Application No: BE/101/21/HH
Site Address: 3 Homing Gardens Bersted PO22 9AJ
Description of works: Replace metal framed/wood panel workshop in rear with brick-built workshop
(This application may affect the character and appearance of the North Bersted Conservation Area)

Thank you for your internet representation made on 15th November 2021 which has been recorded as an objection with the comments as follows:

Please accept this letter as an OBJECTION to the proposed workshop at 3 Homing Gardens.

extending homes Tel:- 01243 555208 enquiries@extendinghomes.co.uk	
TITLE:- Outbuilding @ 3 Homing Gardens North Bersted West Sussex PO22 9AJ	
DATE:-	2nd September 2021
SCALE:-	Elevations Scale 1-100 on A2 Paper
DRAWN:-	P.Robinson
DWG. No. 2021078/PL/1

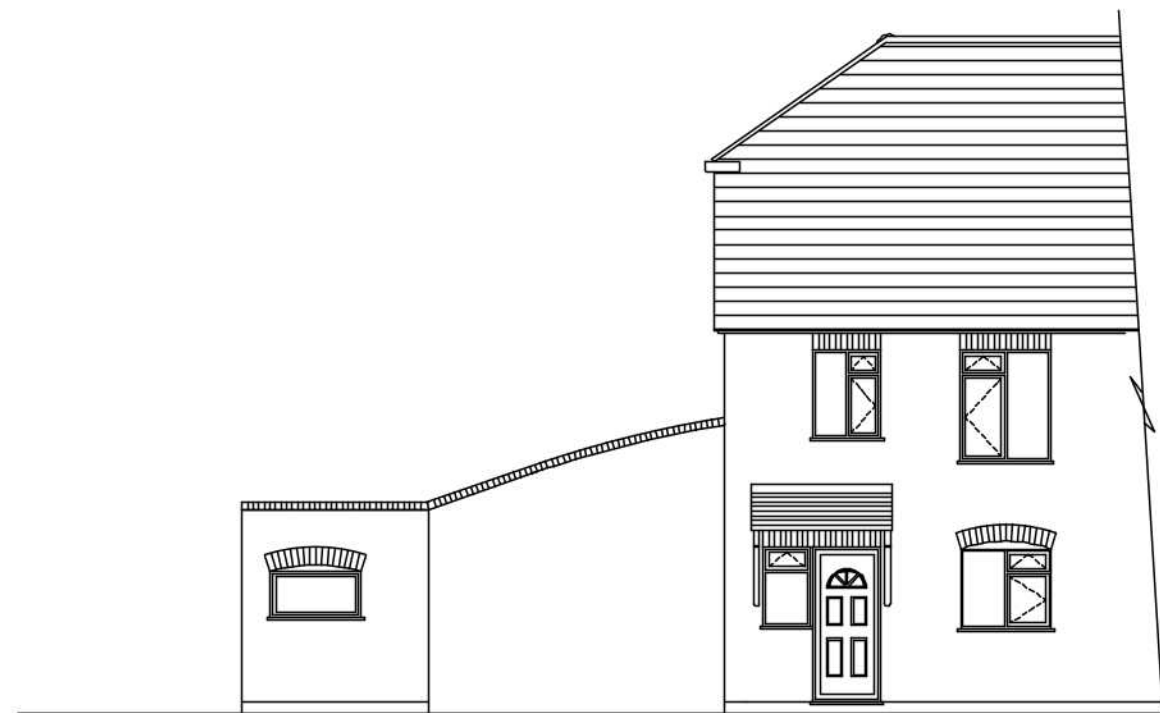
A window is shown on the drawings of the proposed workshop which faces into the garage area. The size of this window could easily be cut down into a door at a later stage, thereby giving access to the workshop from the garage area. Having a window at the end of a row of garages is a security risk from the public footpath that runs the whole length of the garage area. The area is clearly for garages and to introduce windows facing a public footpath could encourage unwanted scrutiny.

The design & access statement for this application states that the proposer has spoken to all his neighbours regarding this build but he has never spoken to us about this, nor have we discussed any "ideas" with him. I understand that this is the same with the rest of the neighbours. The proposed plans seem to show the roof area higher than at present, another issue that could cause unwanted scrutiny from the public footpath.

Proposed SWW Elevation
Neighbouring House not shown for Clarity

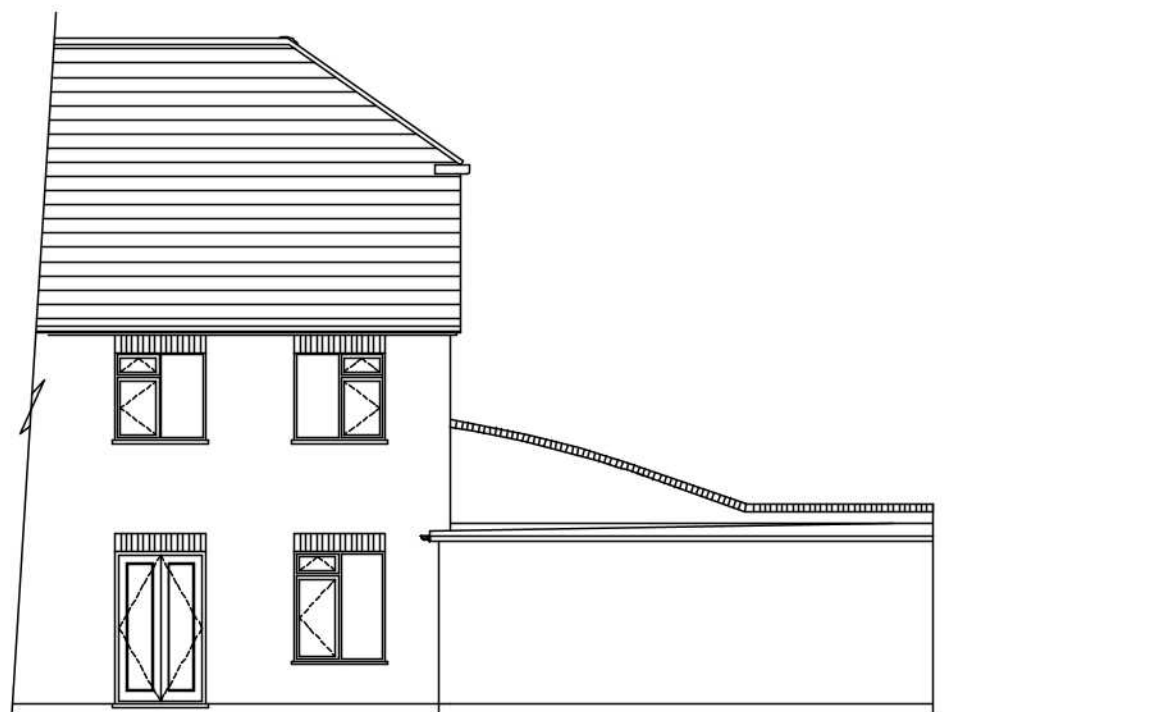
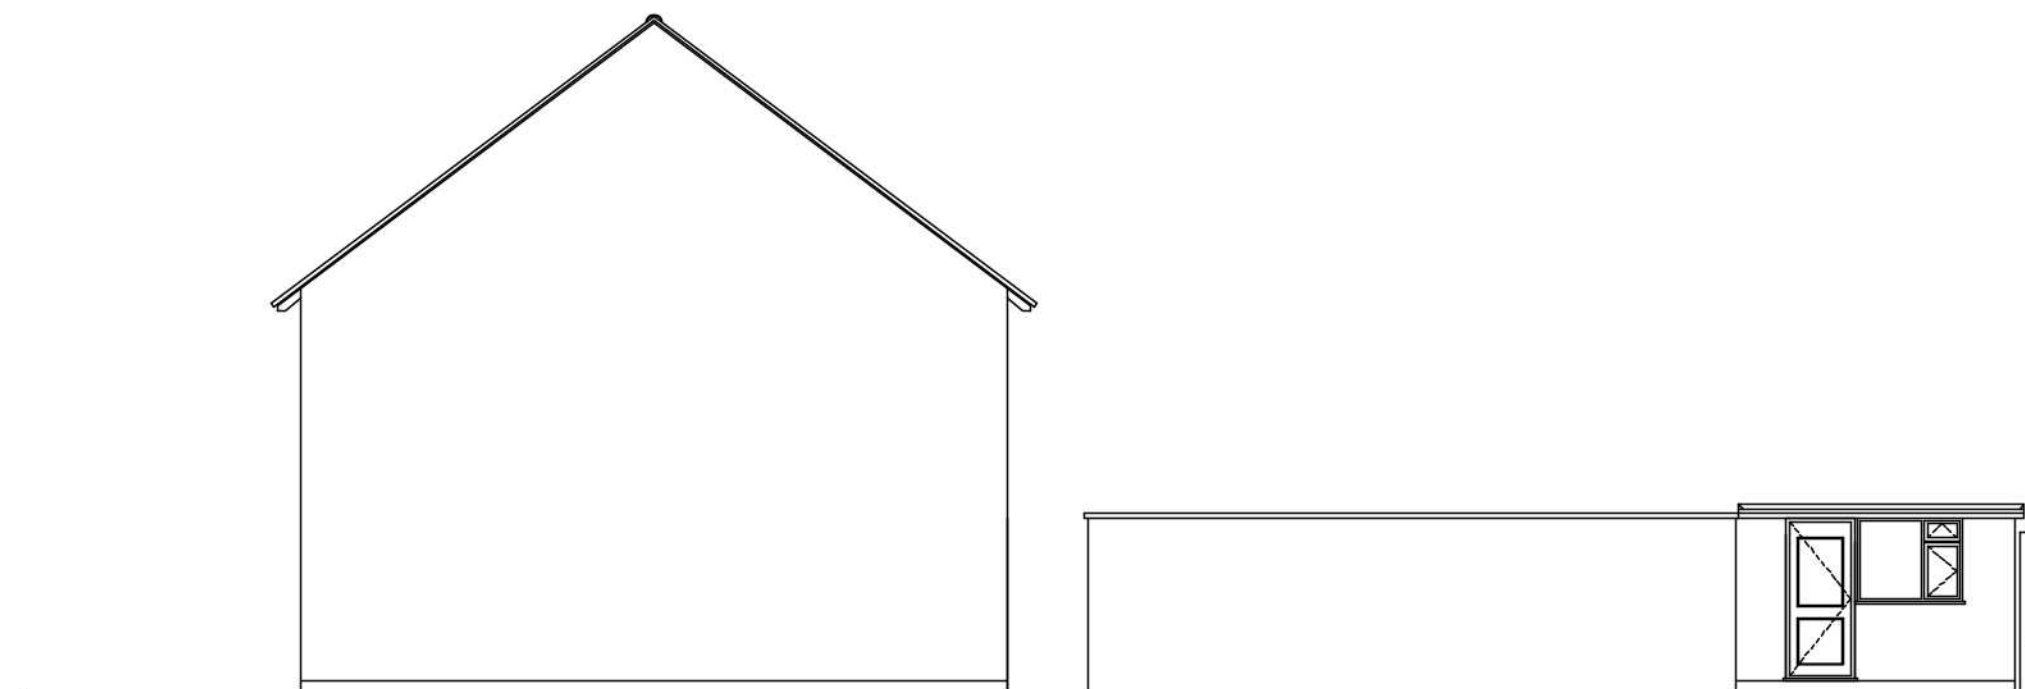
There does not seem to be any detail of how the proposed structure is to be attached to the garage of No 7 Homing Gardens nor how the roof should be supported so that it is not solely relying on the single skin wall of No 7, to support the new roof structure.
